WEST SUSSEX COUNTY COUNCIL CONSULTATION

TO:	Arun District Council FAO: Michael Eastham
FROM:	Highways, WSCC: Tim Townsend
DATE:	15 th November 2018
LOCATION:	Land at, Bridge Cottage & The Old Cottage, Lidsey Road, Bognor Regis, PO22 9PH
SUBJECT:	AL/20/18/OUT Outline application with all matters reserved for the demolition of 2 No. dwellings & associated outbuildings & the erection of up to 27 No. dwellings, of which 30% will be affordable, with associated open space & access. This application is a Departure from the Development Plan. <u>Further information.</u>
DATE OF SITE VISIT:	
RECOMMENDATION:	☐ Advice ☒ Objection ☐ Modification ☐ No Objection ☐ More Information ☐ Refusal
S106 CONTRIBUTION TOTAL:	£7,196 per-dwelling towards infrastructure for the BEW Strategic Allocation. Requirements for non-highways infrastructure given at foot of this report.

This is the fourth WSCC highways and transport (CHA) response to the above outline planning application with all matters reserved for the demolition of 2 No. dwellings & associated outbuildings & the erection of up to 27 No. dwellings, of which 30% will be affordable, with associated open space & access. This report responds to additi

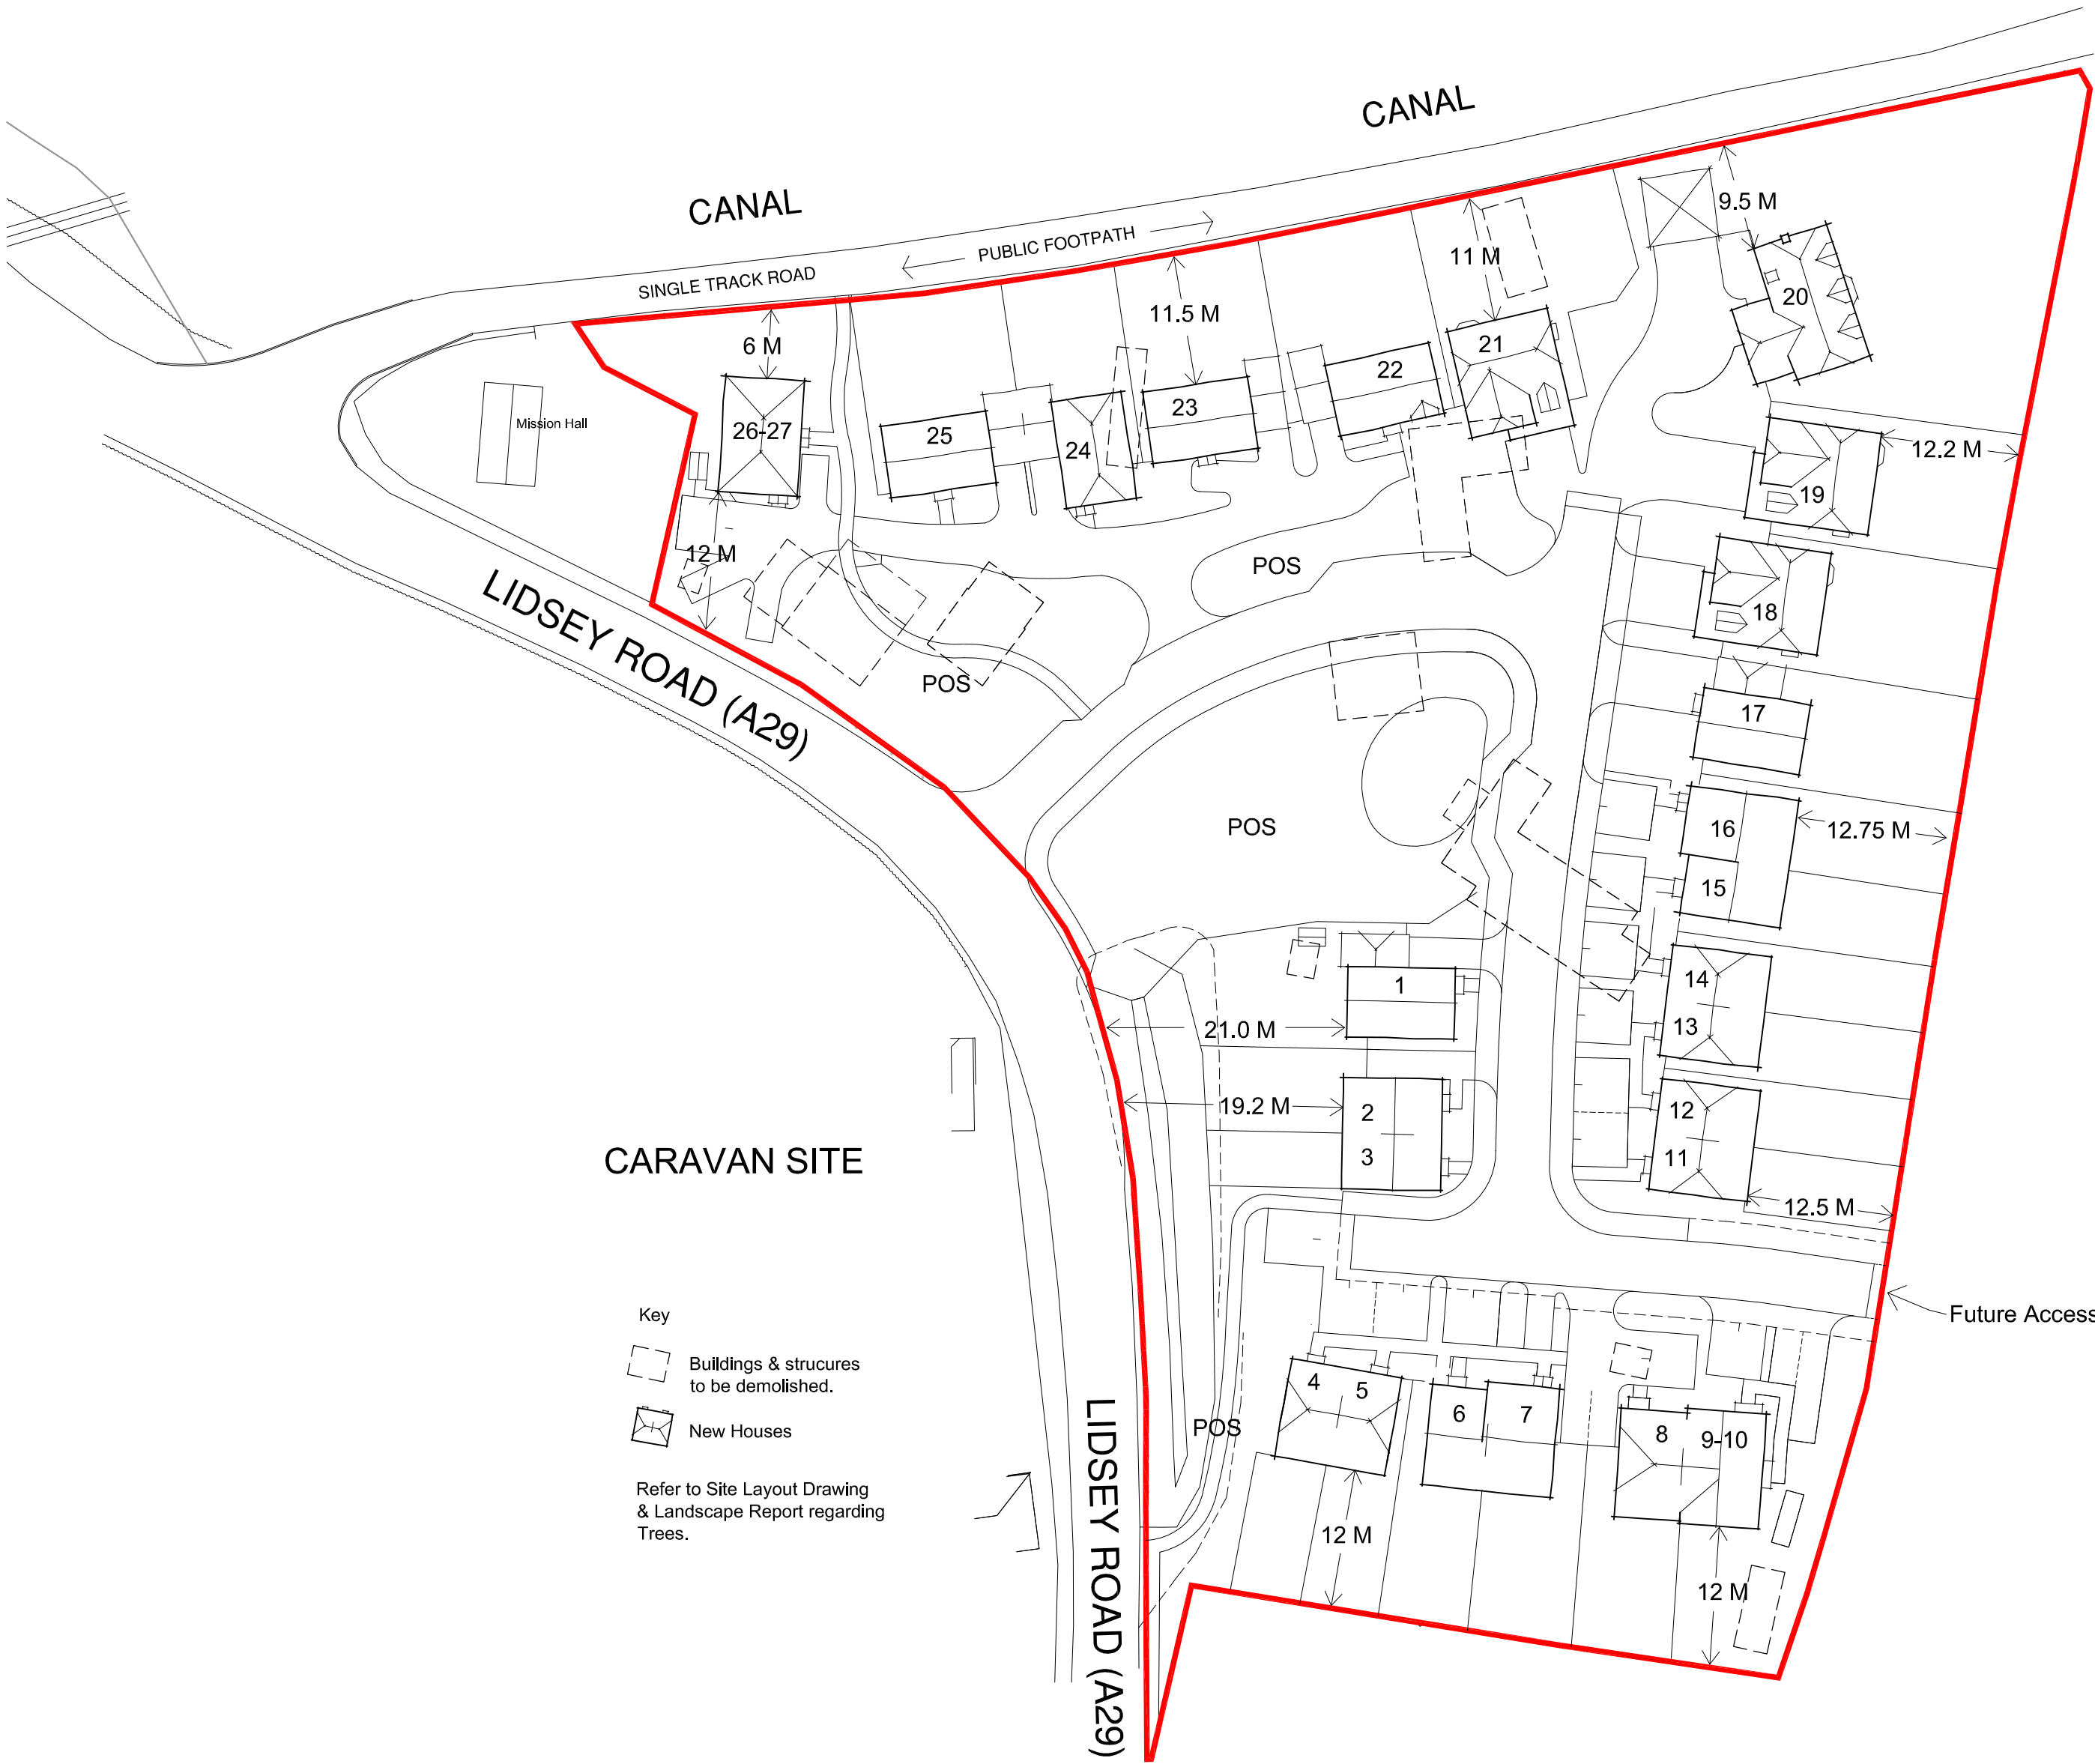
Drawing 1749-02H (illustrative Site Plan) shows that the footway originally shown to the south of the junction has now been removed from the scheme. So too has the footpath further south. However, drawing DWG 1749-02H is a more detailed drawing from that submitted previously and also shows a number of visibility dimensions - namely actual site access visibility and forward/Stopping Sight Distance (SSD) visibility. Alongside this, road width dimensions appear to be shown. However, as this plan shows more detail over that of

previous drawing OCL/SR/701 revision 'D', it now highlights that the lane widths on the bend adjacent to the site access appear to vary in width, whereas on previous drawings this did not appear to be the case. As the matter of access is a detailed consideration of the planning application, there is a requirement on the applicant to show adequate detail at this current planning stage.

With regard to what is shown, approximately 10m south of the proposed centreline of the new access, the southbound lane width appears to be 2.5m wide. Given that the A29 in this location carries a high proportion of HGVs, concern is expressed that vehicles (HGV or otherwise) might over-sail the centreline when travelling south. As such the applicant must demonstrate that all vehicles using this route will be able to do so without over-sailing the centreline of the A29. Tracking diagrams should be provided and alongside this, the applicant should re-visit the design and alignment of the road (including centreline markings) at this point and provide further drawings. Visibility splays should then be re-marked based on any revised alignment resulting from the tracking and re-marking work required. If these are made available, the CHA will review them.

With regard to bellmouth radii (again based on drawing DWG 1749-02H), it is unclear what is proposed because the dimensions, kerb lines shown do not appear to tally with one-another and are generally unclear on the drawing. As such, the applicant should make it clear where kerb lines are proposed.

Again with regard to visibility splays (site access, forward visibility etc.), these will all need to be reviewed in-light of the comments made above about road alignment. Specifically with regard to the site access visibility in the trailing traffic direction (so looking south from the proposed access), this needs to be shown correctly. It currently crosses the centreline of the Shripney Road meaning that some vehicles could be 'lost' outside of the splay area.

Given the concerns expressed above based on that shown on DWG 1749-02H, the CHA recommends that an objection based on substandard access design be reinstated (and that it sits-alongside the other highway objection already made based on sustainable access):

"Adequate information has not been submitted to satisfy the Highway Authority that the proposal is acceptable in terms of road/junction layout, carriageway (and lane) width/s and visibility splays (including forward visibility/stopping sight distance splays) and would therefore give rise to increased hazards to highway users contrary to the NPPF and adopted Local Plan policies."
